Our Ref: PLAN-000867

21/08/2012

Proposal: Alterations to car park layout, access and landscaping.
Site: Focus, Unit A New Road, Rustington BN16 3RT.
R/149/12/

CHQ.11.9647 - TS PL03

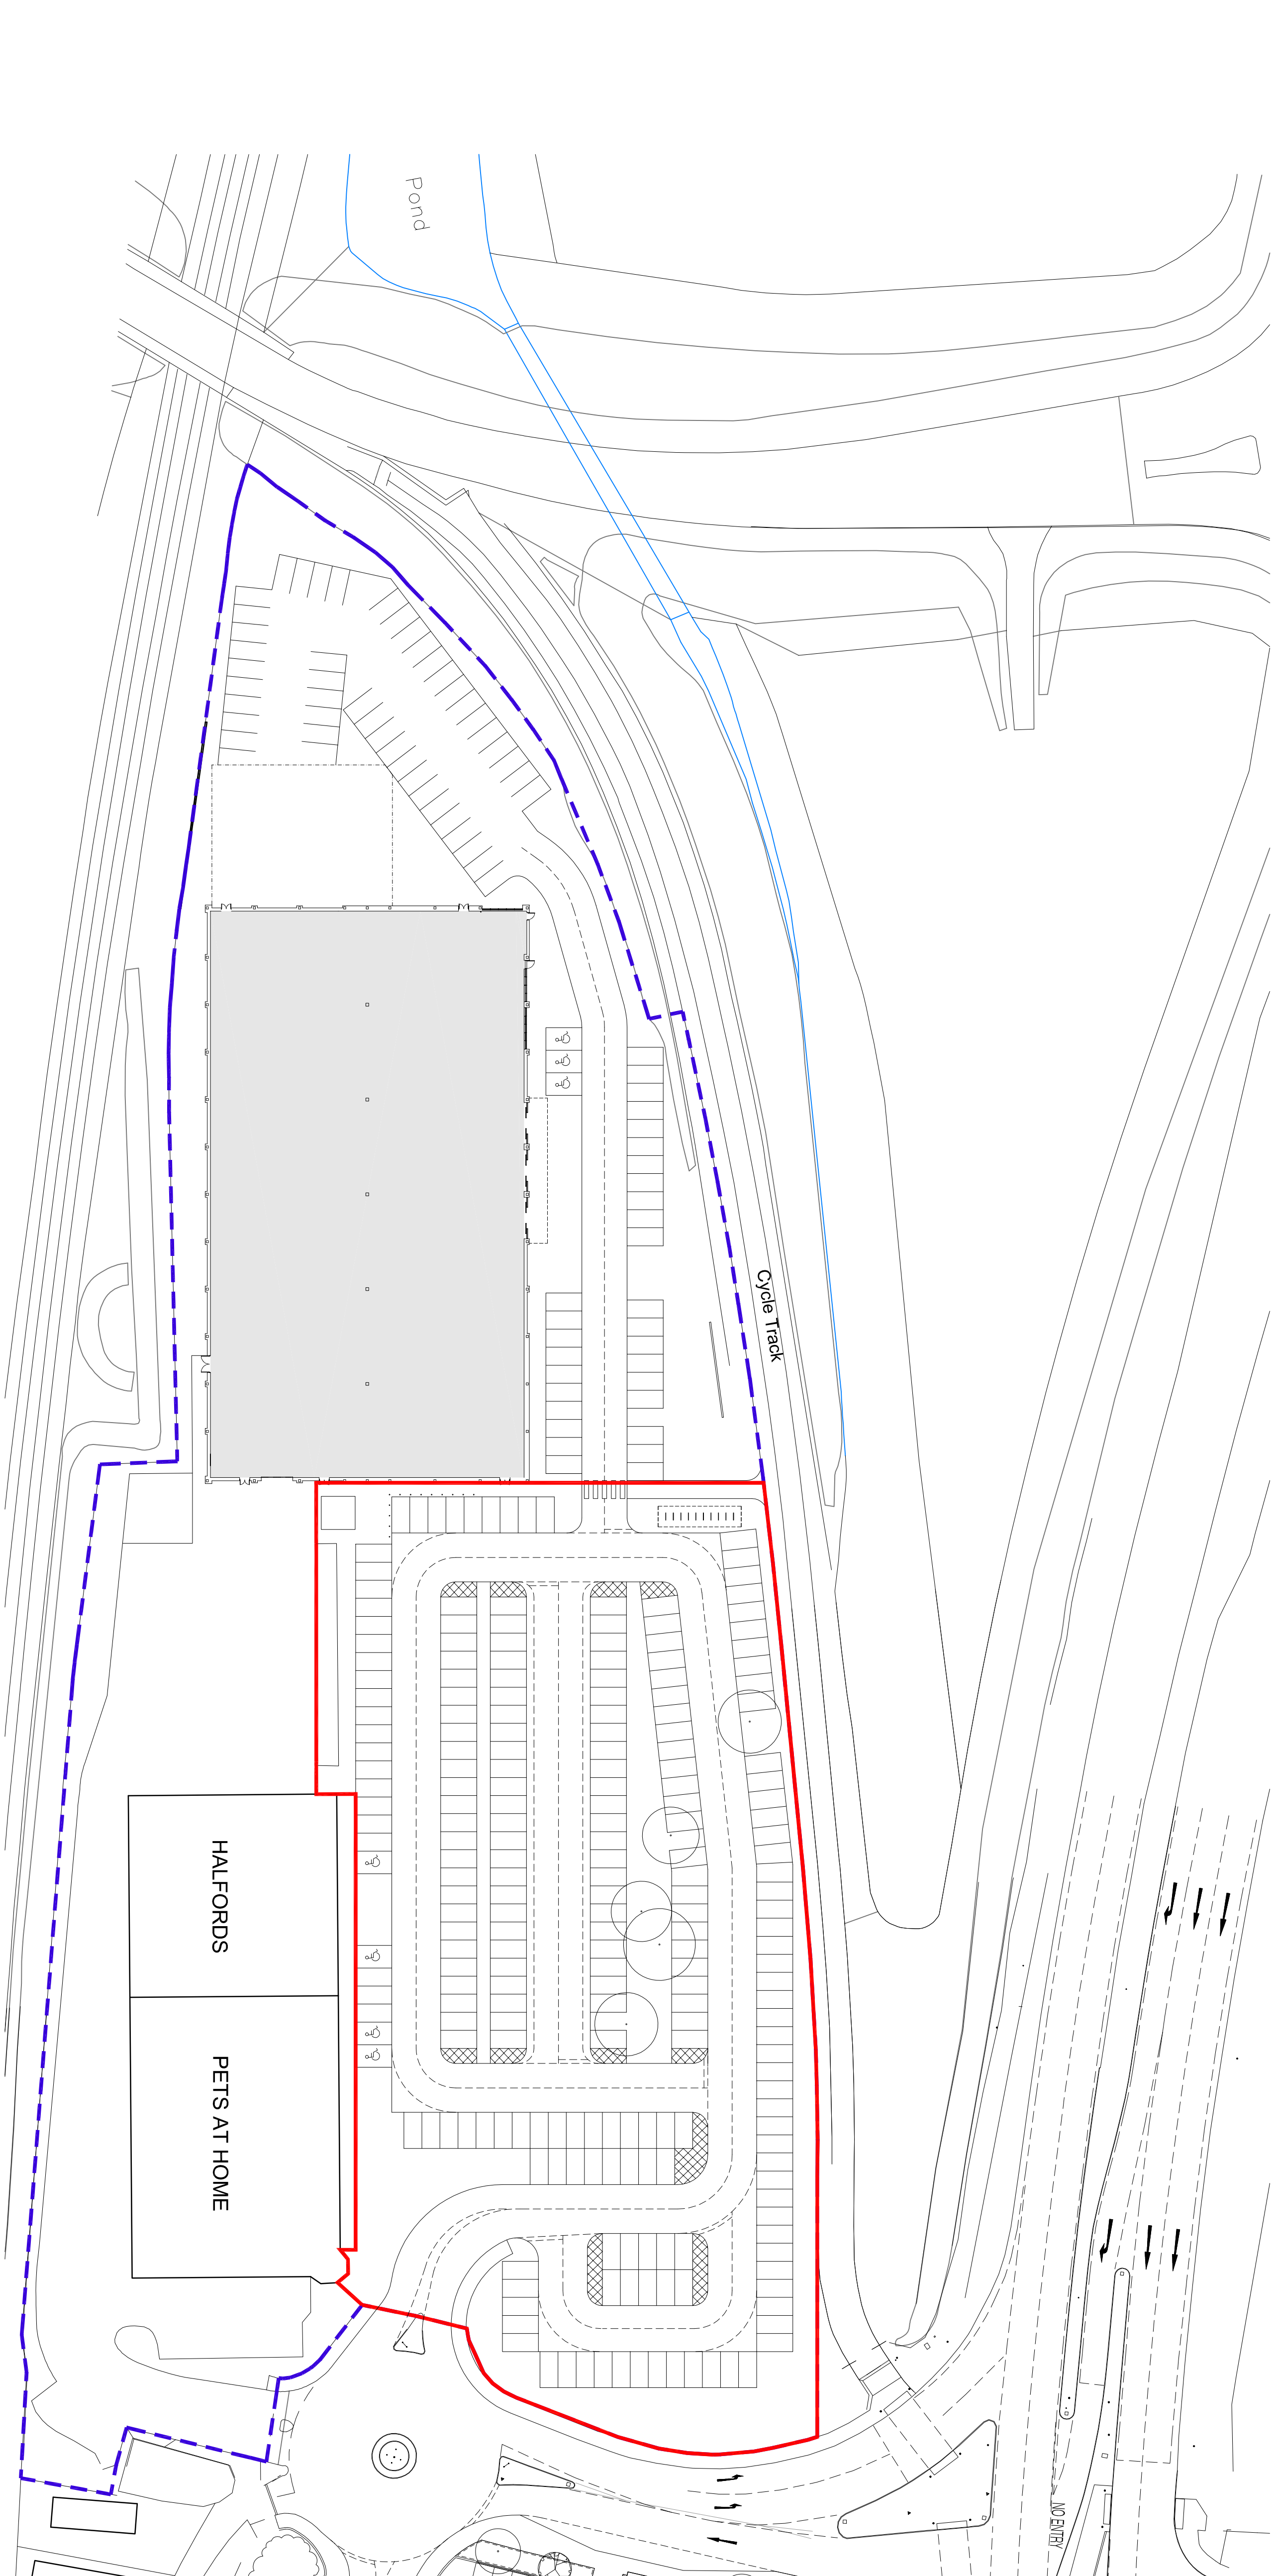
Please find attached a plan of the water main records showing the approximate position of a public water distribution main in the immediate vicinity of the site. The exact position of the public water main must be determined on site by the applicant before the layout of the proposed development is finalised.

All existing infrastructure, including protective coatings and cathodic protection, should be protected during the course of construction works. No excavation, mounding or tree planting should be carried out within 3 metres of the public water main without consent from Southern Water.

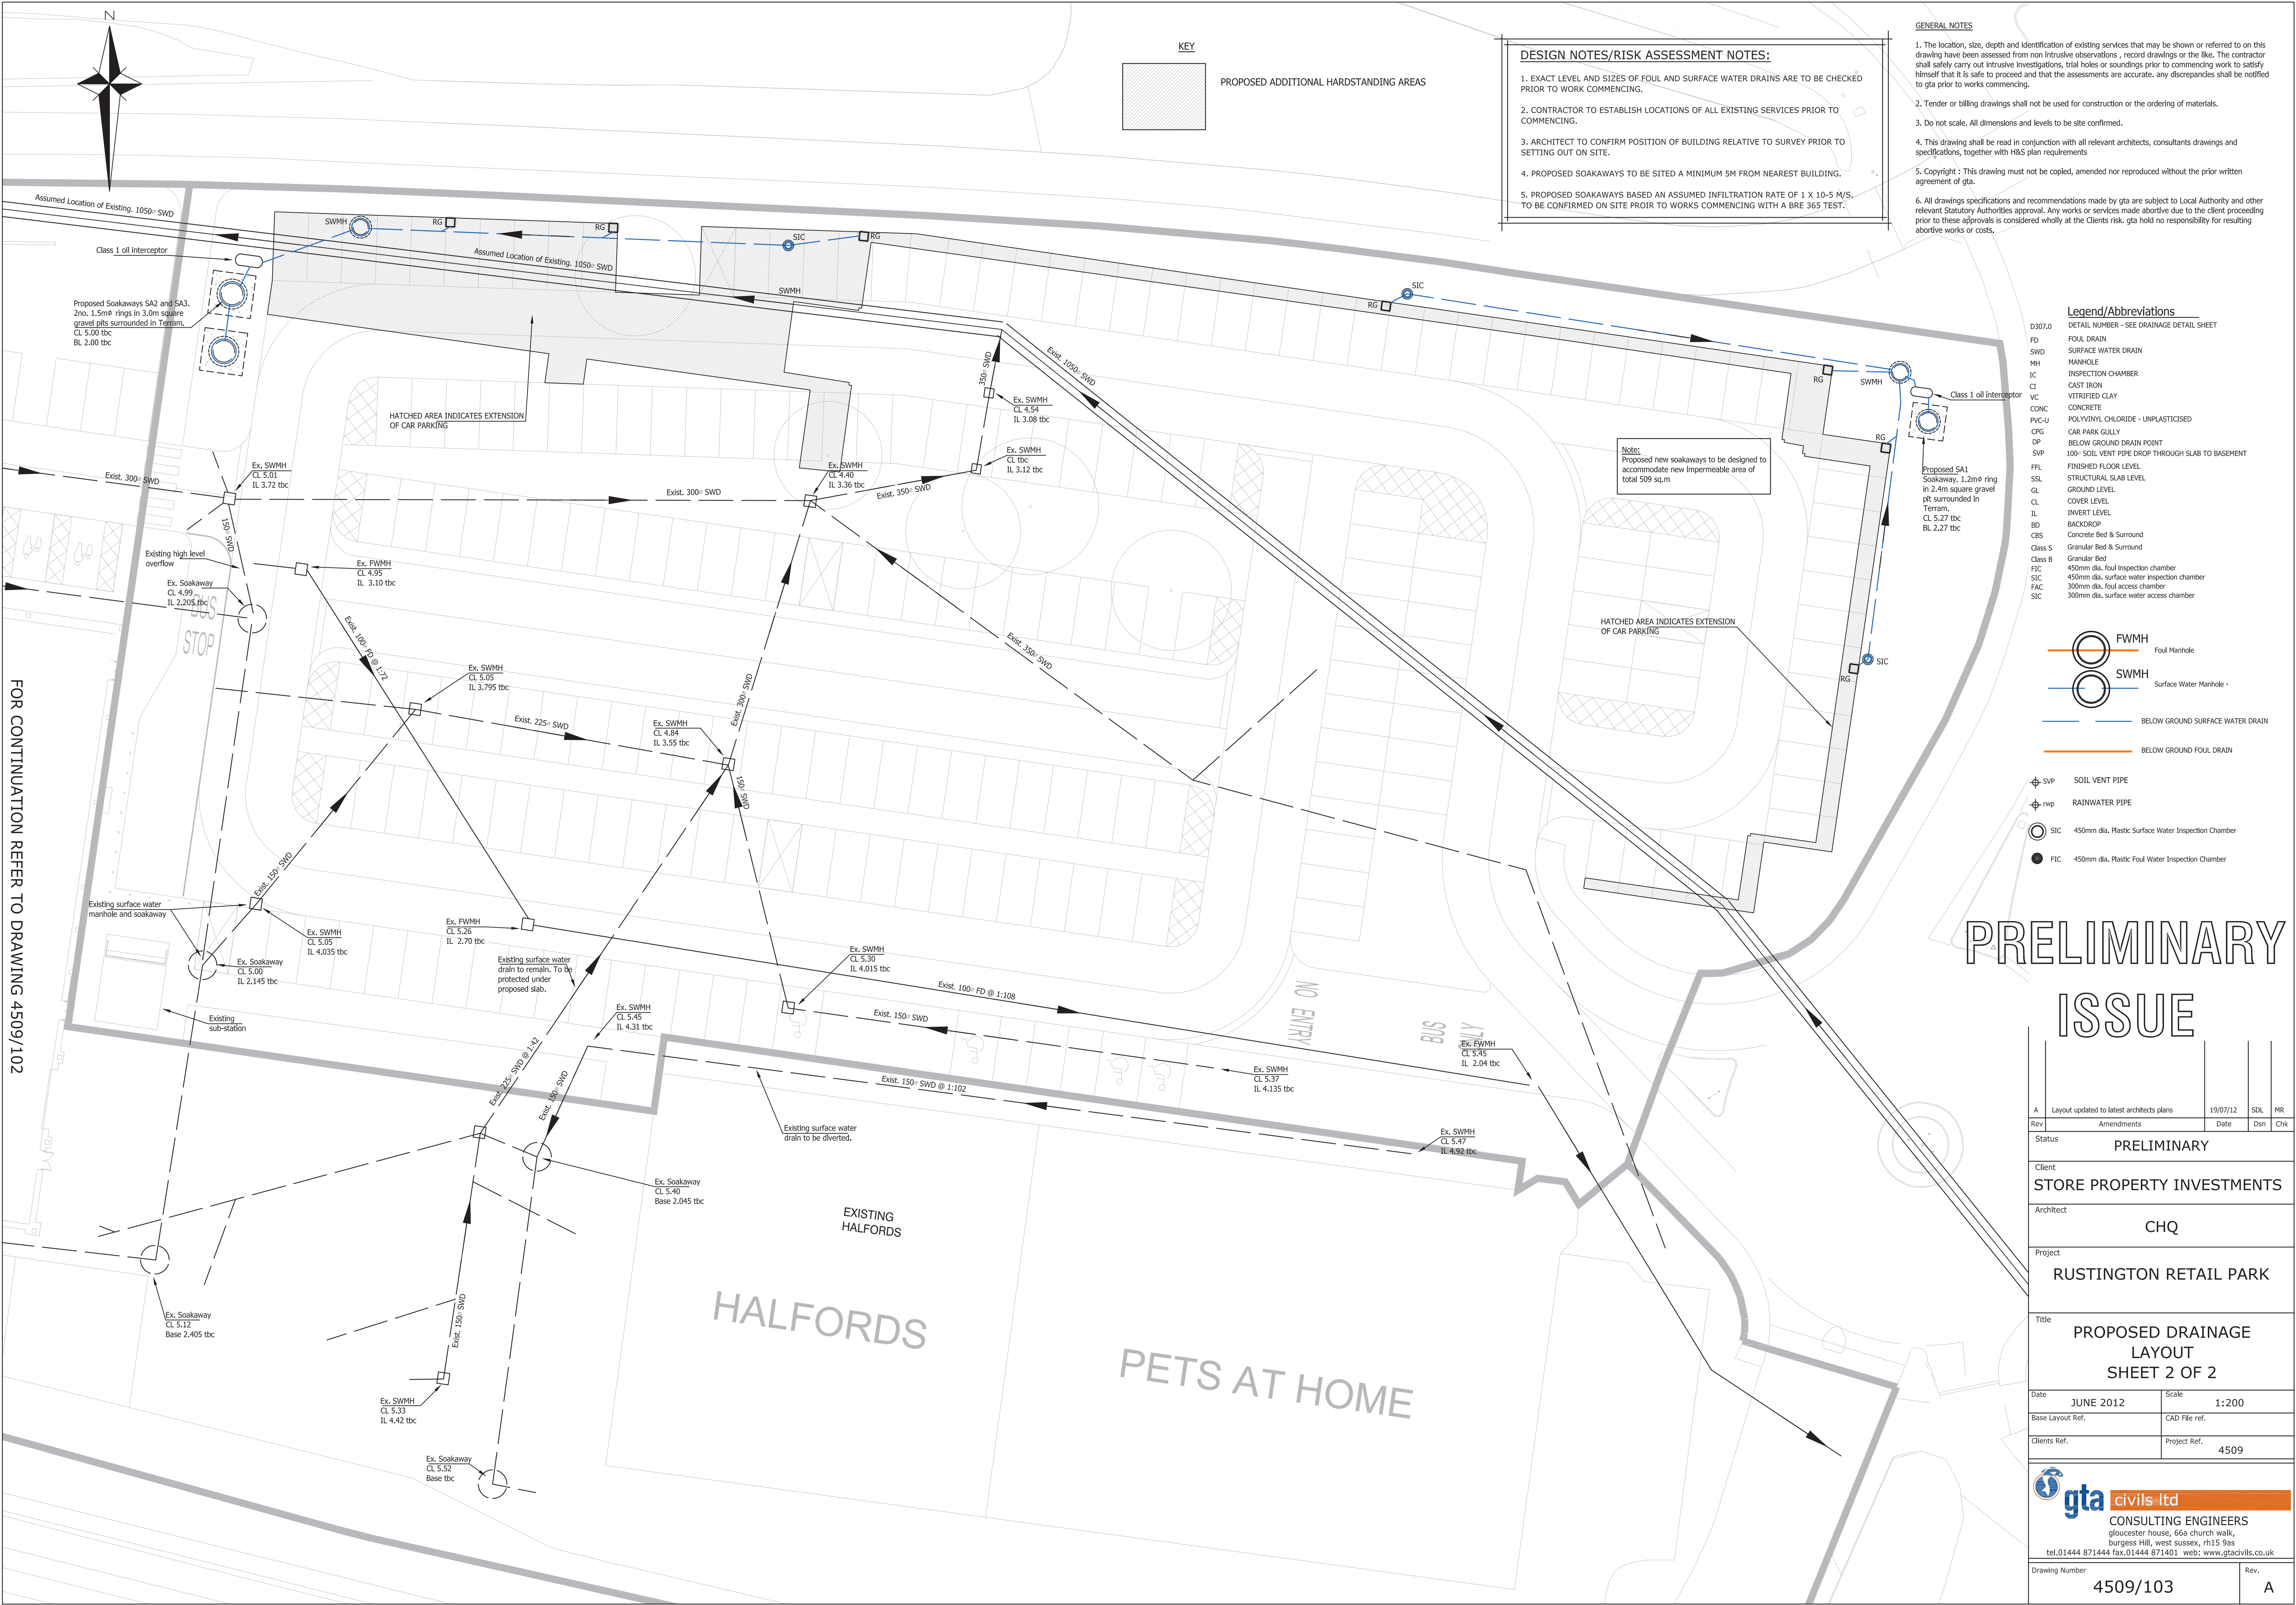
The application details for this development indicate that the proposed means of surface

water drainage for the site is via a watercourse. The Council's technical staff and the relevant authority for land drainage consent should comment on the adequacy of the proposals to discharge surface water to the local watercourse.

The Council's Building Control officers or technical staff should be asked to comment on the [REDACTED] use of surface water from the proposed development.
